Consultation Response from Chris Bembridge KC, Highways Development Management
2023/91280 Bromley Farm Quarry, Barnsley Road, Upper Cumberworth, Huddersfield, HD8 8PD
Quarrying operations for the extraction of clay, shale and incidental coal and subsequent restoration by means of importation of inert wastes
Date Responded: 21/02/2025 Responding Officer: CNB Responding Ref: K17-3/6

This application is for the formation of a new quarry utilising the existing access of a previous and now depleted and restored quarry on to A635 Barnsley Road, a 40mph two-way single carriageway primary distributor road of approximately 9m width with footways on the side of the application site and street lighting present. There is a hatched central reserve and a right turn lane in to the site.

Plan Title: CROSS SECTIONAL DETAIL FOR QUARRY WORKINGS TO HIGHWAY

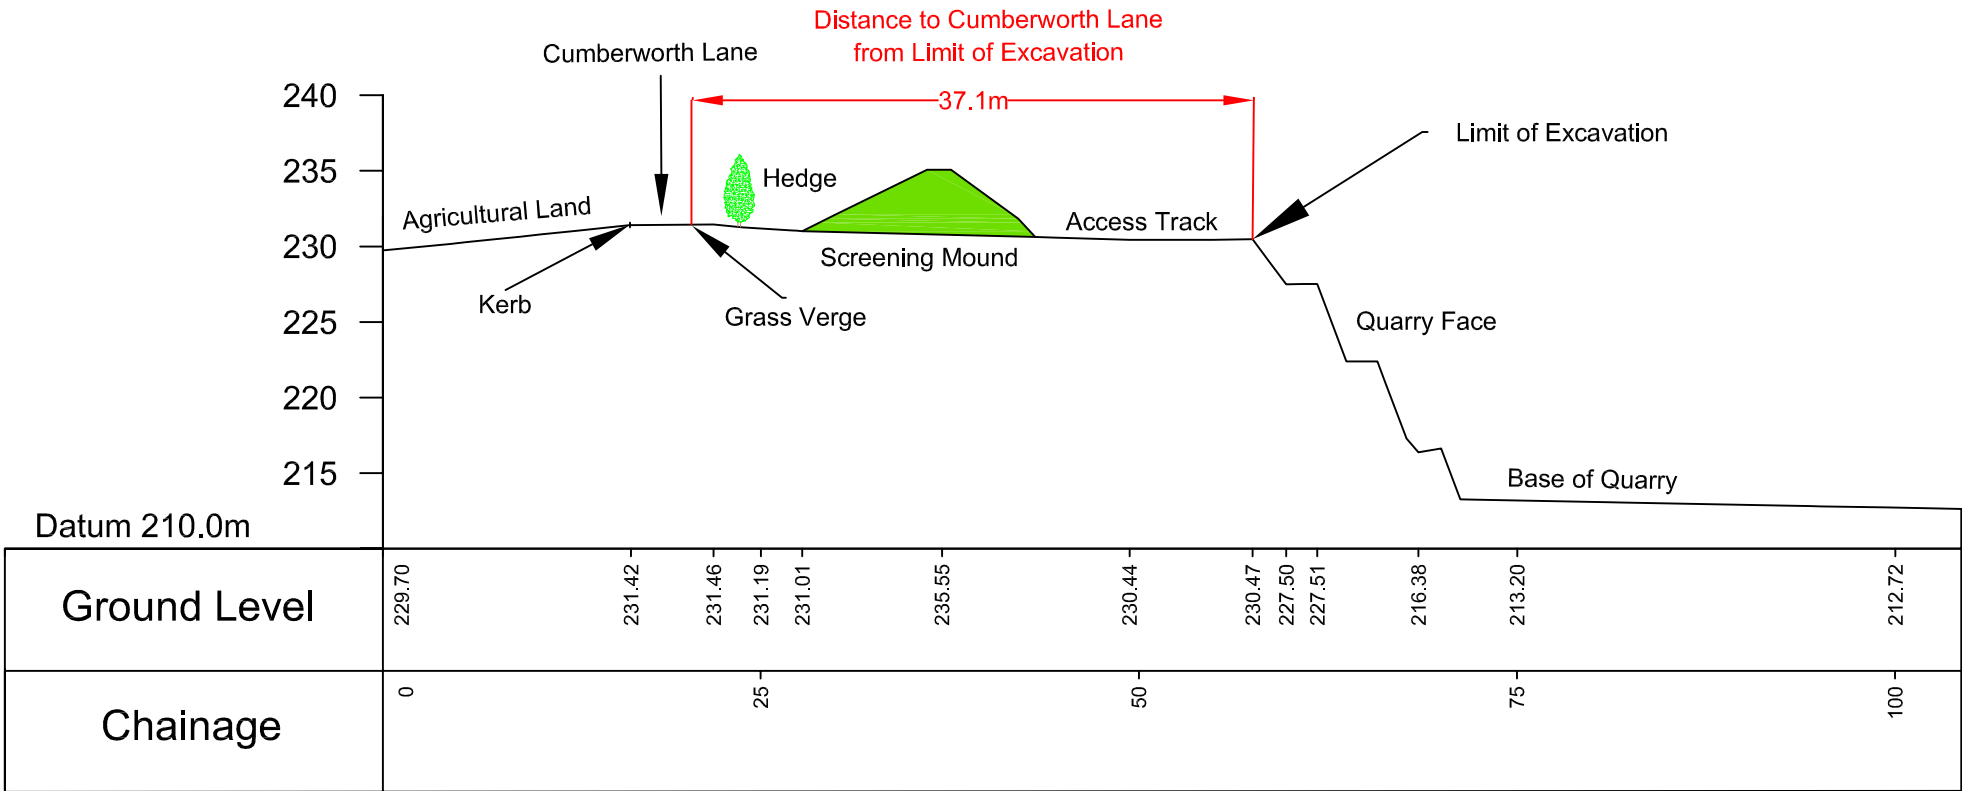
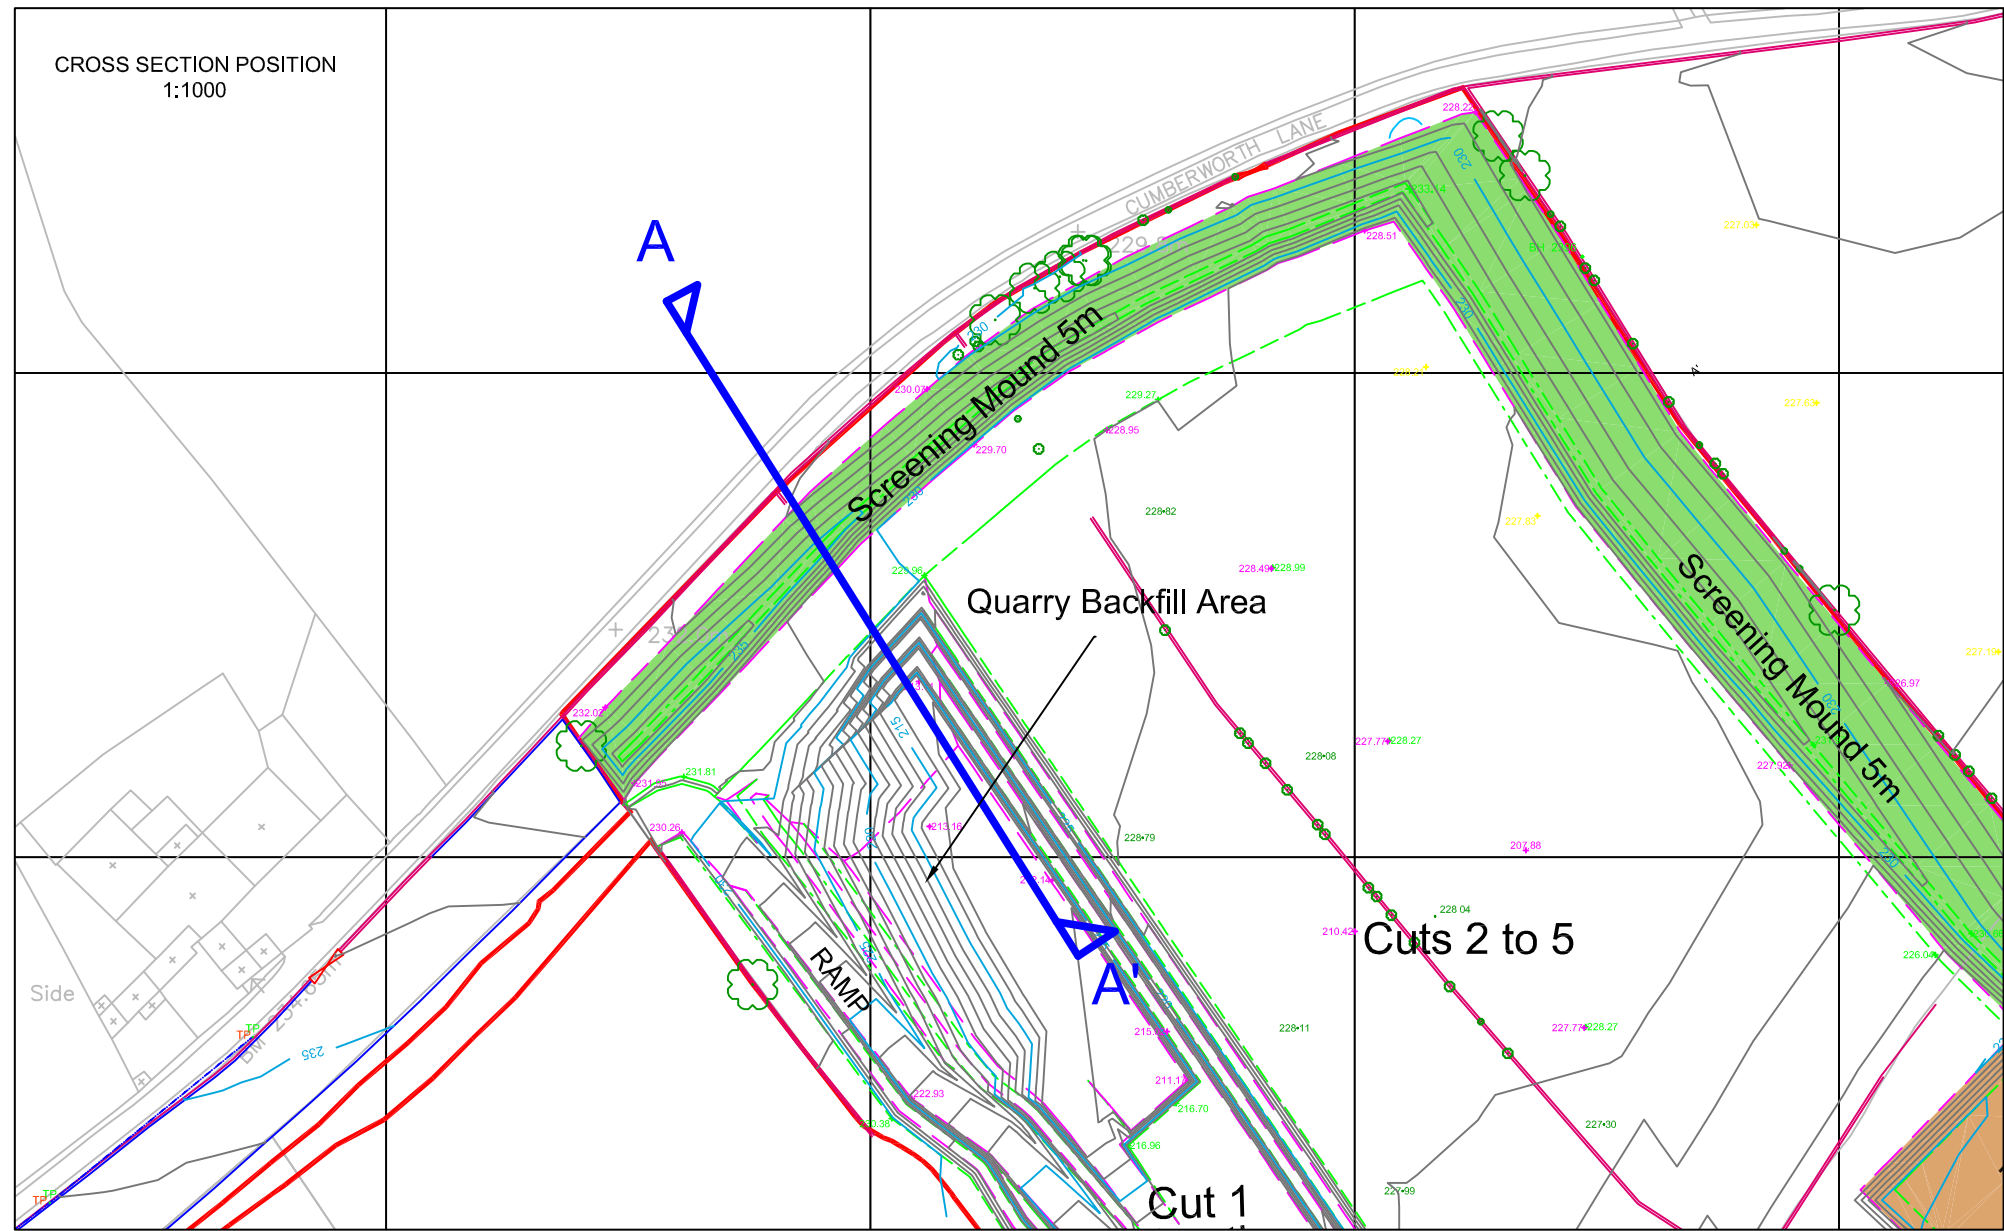
The access gate for the quarry is to be set back from the shared access road by approximately 17m, this is to allow a single articulated HGV to wait for the gate to be opened without obstructing the access road for highway safety reasons. This is shown on drawing No. 22007/511 Rev A. Again, this should be constructed prior to the quarry being brought in to use, and this should be conditioned. It is noted that in the event of two HGVs arriving at the same time, there would be space for two to wait side by

side within the 17m, however this would not allow an exiting vehicle to pass. This would not be expected to be a regular occurrence and management of the gate/access would be controlled. Operation of the gate can be included in an Access Management Plan, and this can be conditioned.

Notwithstanding the provisions of the Town and Country Planning (General Permitted Development) Order 1995, (or any order revoking and re-enacting that order) any gates or barriers for or over a vehicular access or egress shall be set back 17m from the back of the junction with the shared access road, as indicated on drawing No 101A, and shall be hung as to only open inwards. So long as such gates or barriers are in position they shall be retained to only open inwards.

HGV ROUTING PLAN

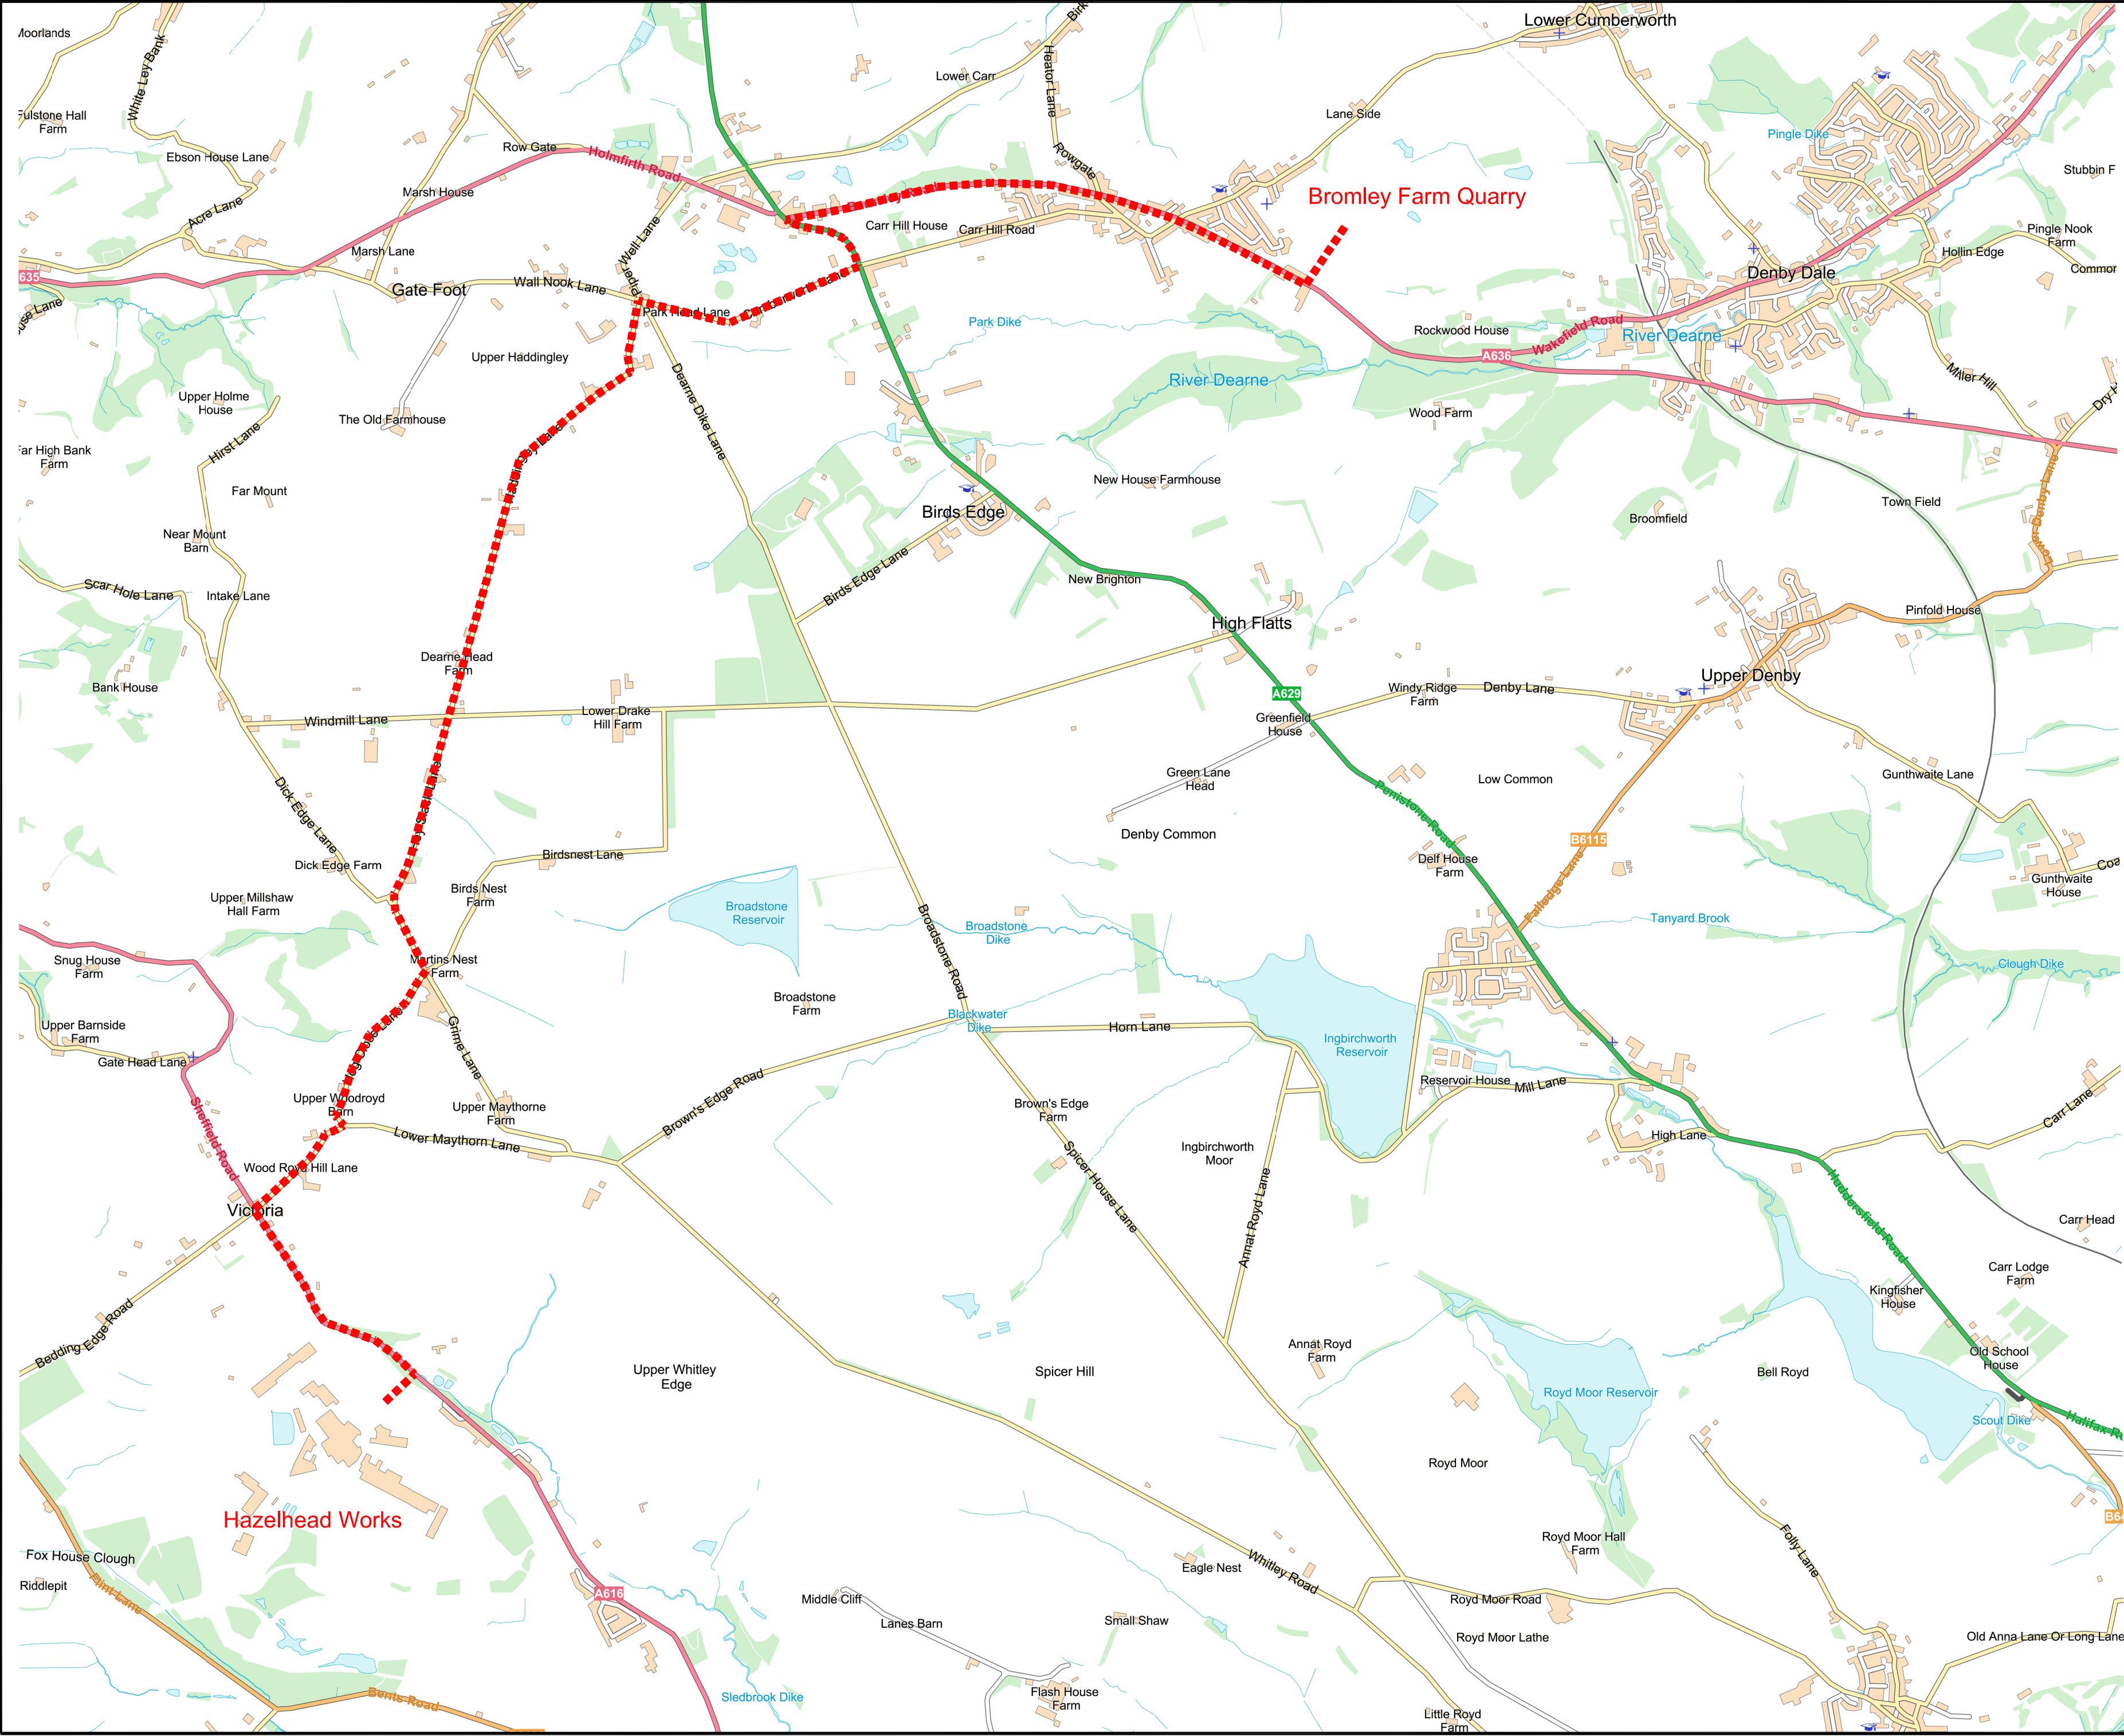
This is shown on drawing No 22007/517 Rev A and is along all-purpose A-roads between the access road to the quarry and the Wavin production site in Barnsley district. This is an improvement over the previous suggested route that used unclassified rural roads that may have been unsuitable for the intensification of HGV trips that the proposals would generate.

Consultation with Barnsley Highways indicated that use of the A-road network to route the HGV trips would be without issue.

Means of vehicular routing for HGVs between the site and the Wavin Crow Edge Works shall only be as shown on the approved routing plan (Drawing No 22007/517 Rev A) and retained thereafter for the lifetime of the removal of minerals from the site.
